The Design Review Panel

Site	Oxpens Wigginton, Banbury, Oxfordshire, OX15 4JZ
Proposal	Proposed Para 79 House
Local Authority	Cherwell District Council
Applicant	Virginia Sweetingham
Agent	Hughes Planning
Architect	Seymour-Smith Architects
Landscape Architect	Seed Landscape Design
Review Date	13 th February 2020

The session was booked by Virginia Sweetingham, and this is the second time The Design Review Panel has reviewed this scheme. The first session was held on the 15th November 2019 and included a site visit.

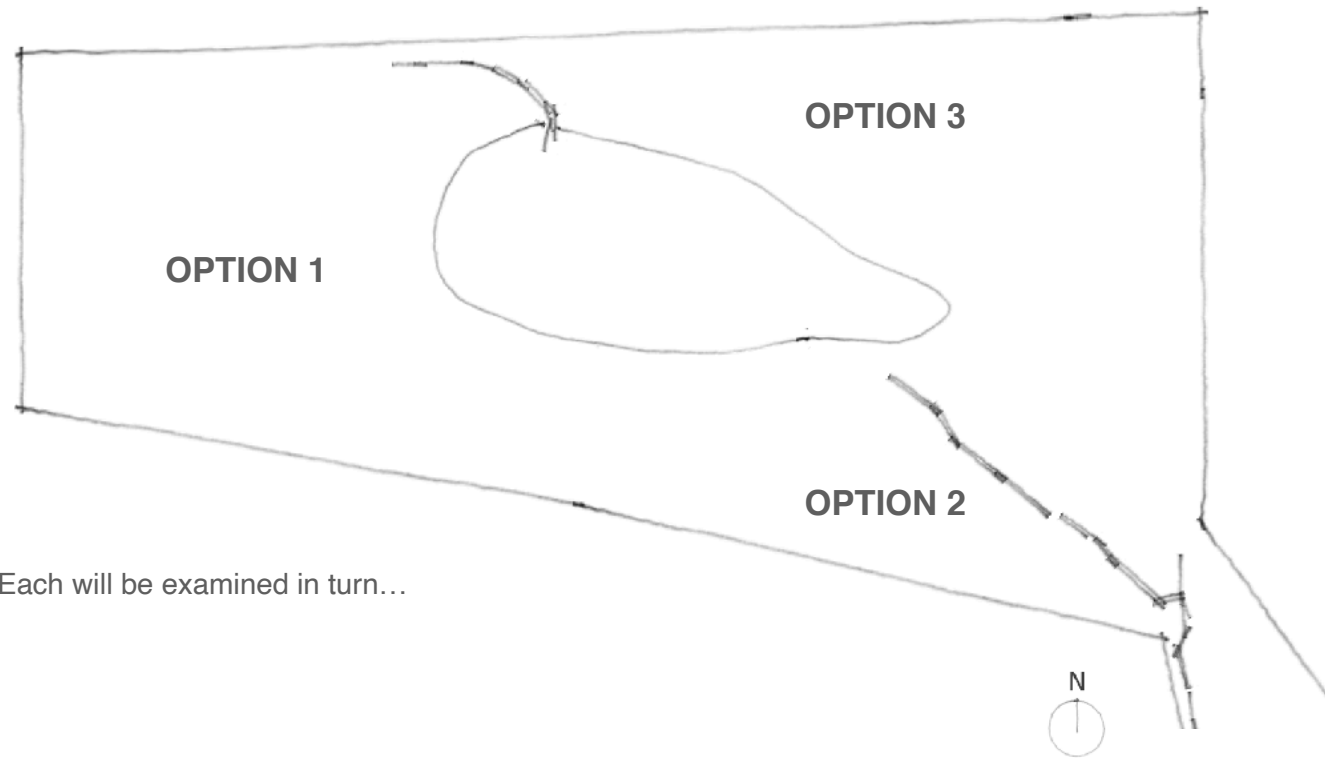
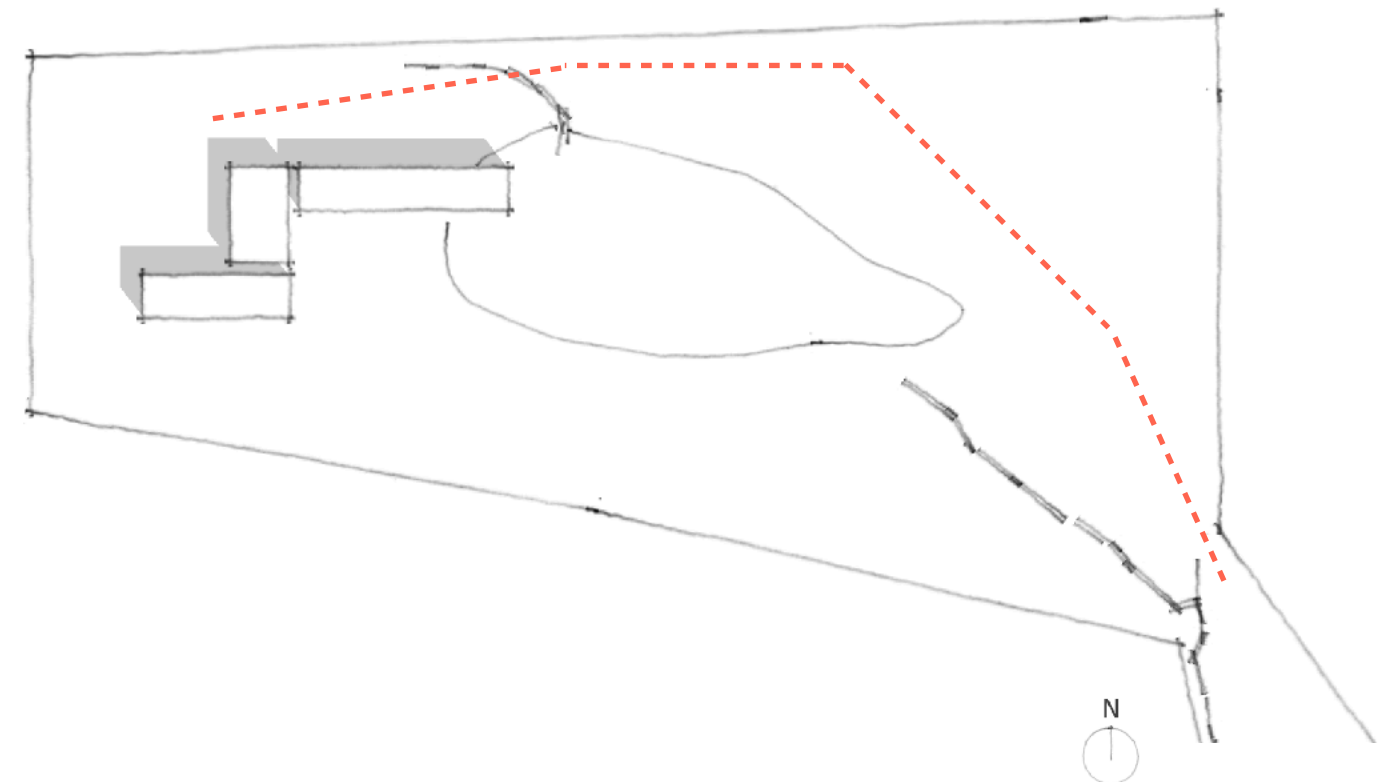
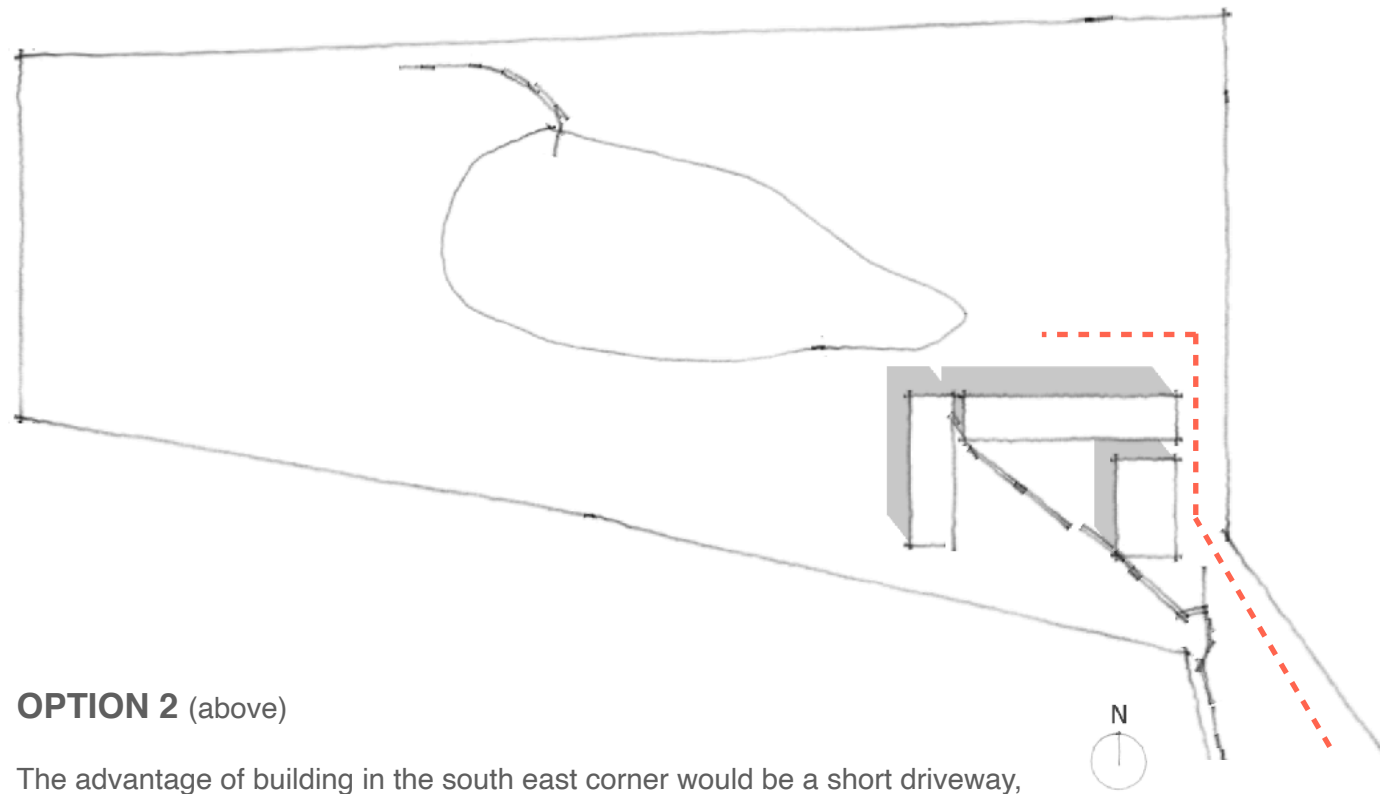
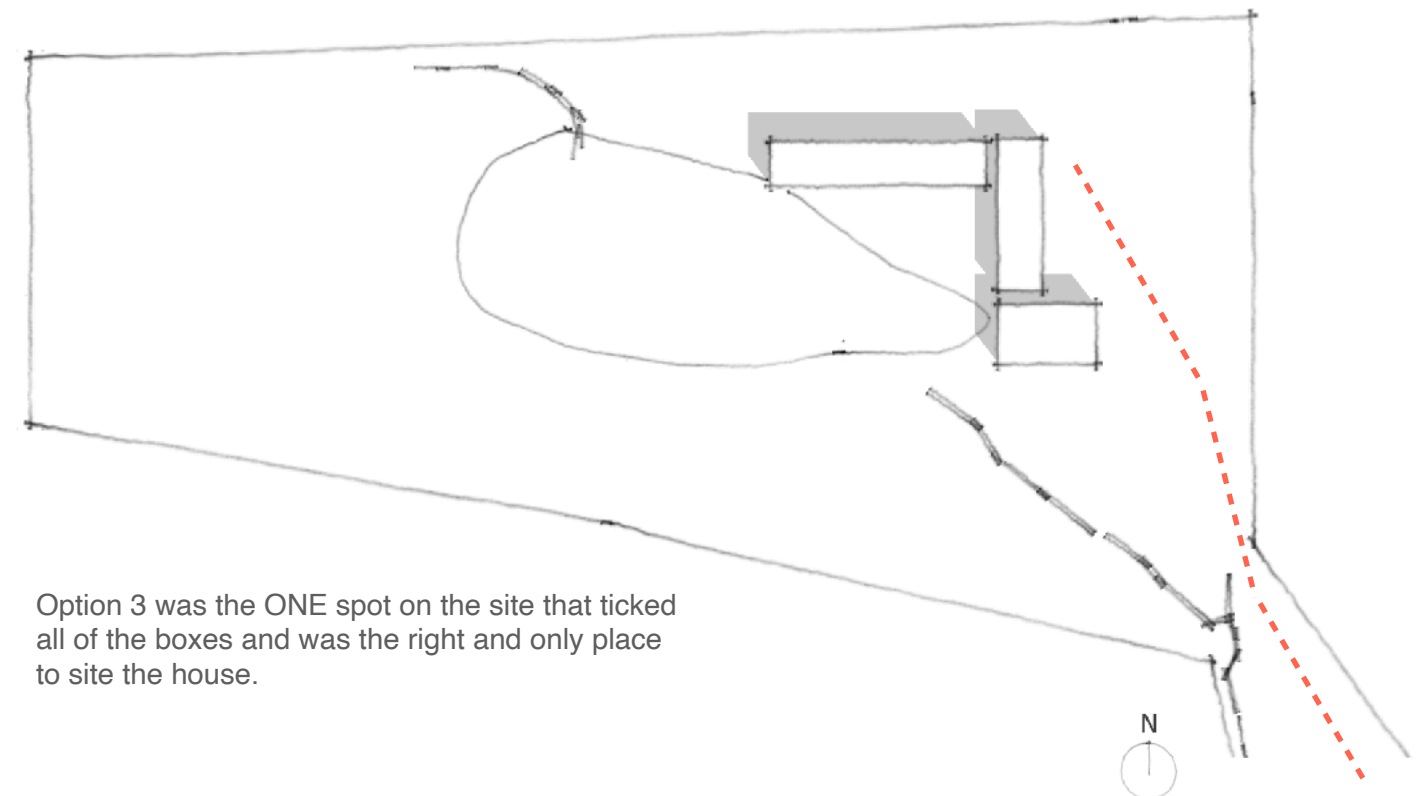
The Panel welcomes and supports the optioneering exercise regarding alternative siting options for the proposed building; it is considered that this exercise has clearly demonstrated a logical reasoning behind the proposed siting. Regarding outward views, it is noted that the proposals appear to focus upon one particular outward view, and it is suggested that it may be beneficial to demonstrate within the presentation sketches that other outward views have also been considered and informed the design.

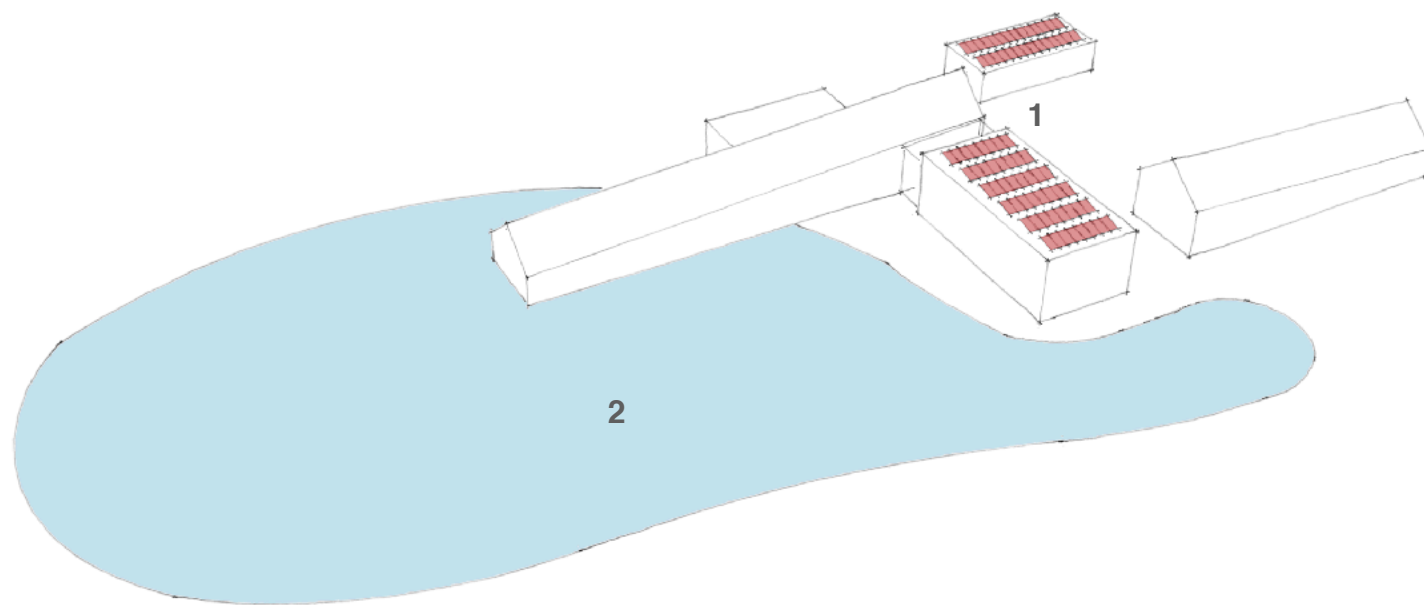
The Panel is supportive of the fabric first approach being undertaken. Notwithstanding this, there is a concern regarding overheating. The proposed use of trees to provide shadowing and therefore passive cooling is noted and supported. It is also noted that the solar shading strategy relies upon the integration of external blinds / shutters. There is a concern that the proposed external blinds /shutters may restrict outward views; a strong winter sun may require the shutters to be closed so as to stop glare and or overheating. It is therefore suggested that this approach may benefit from further consideration.

- The fabric first energy strategy is supported but is not considered to result in the design being considered truly innovative.
- There is a concern regarding overheating & there is a concern that the proposed external blinds /shutters may restrict outward views.
